Updated Firethorn Application 21/01630/OUT Transport Assessment

Analysis by Elmsbrook Residents' Traffic & Parking Group, 22 December 2021

DRAWING No.		
4600-1100-T-041		
DRAWN	APPROVED	DATE
EP	MK	JAN 22
SCALE		REV
1:500 @ A3		A

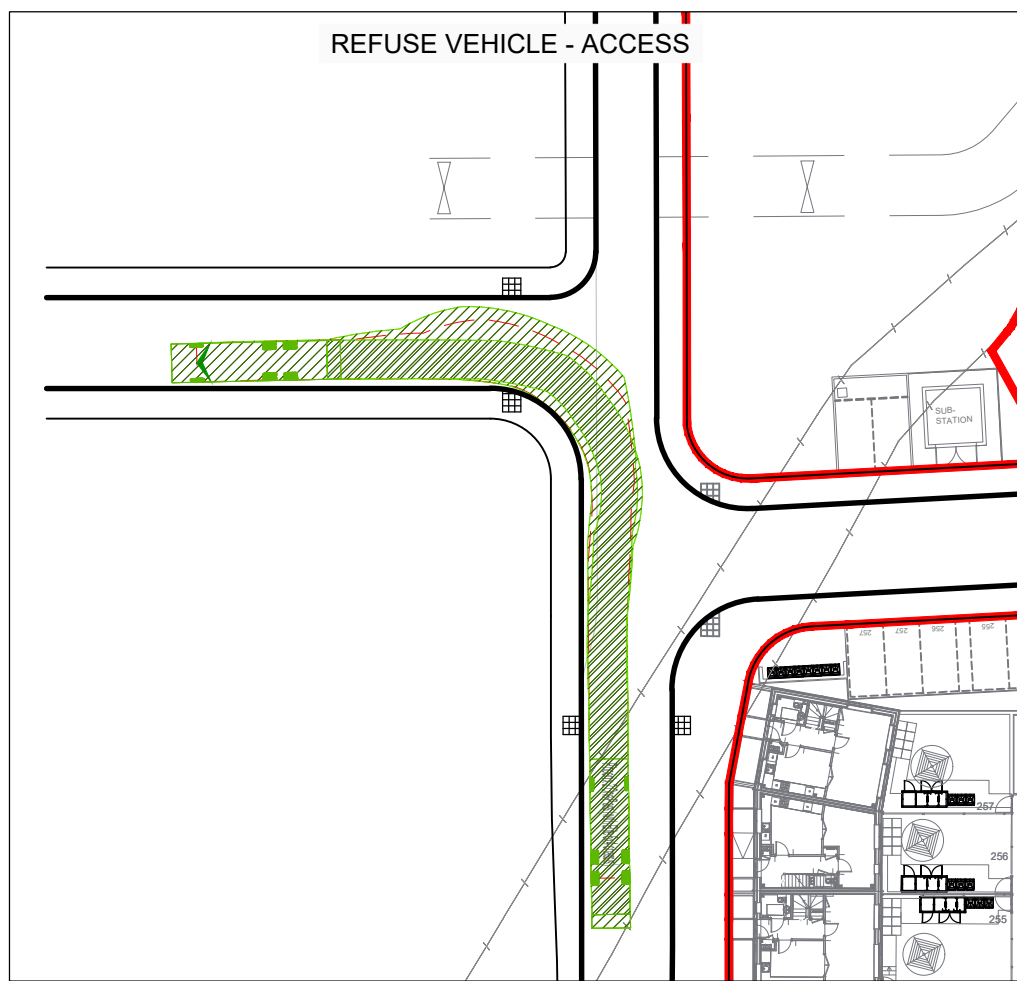
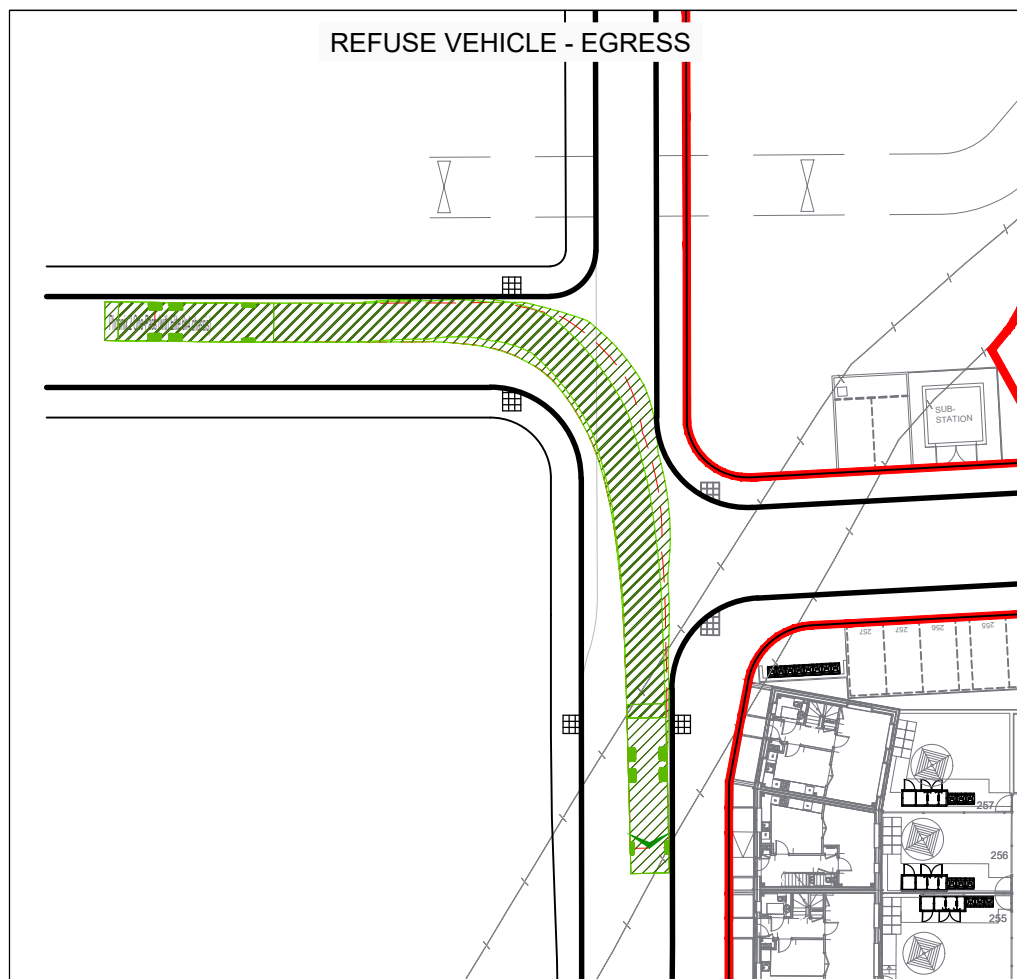
Site Access A is a short spur on the end of Charlotte Avenue, which contains several parking spaces directly onto the road, in a row, and a charging point: if it becomes the entry section to a road serving 138 new homes, this would not appear to be a “safe” location to have so many end-on access points for slow-moving vehicles accessing spaces or the charge point.
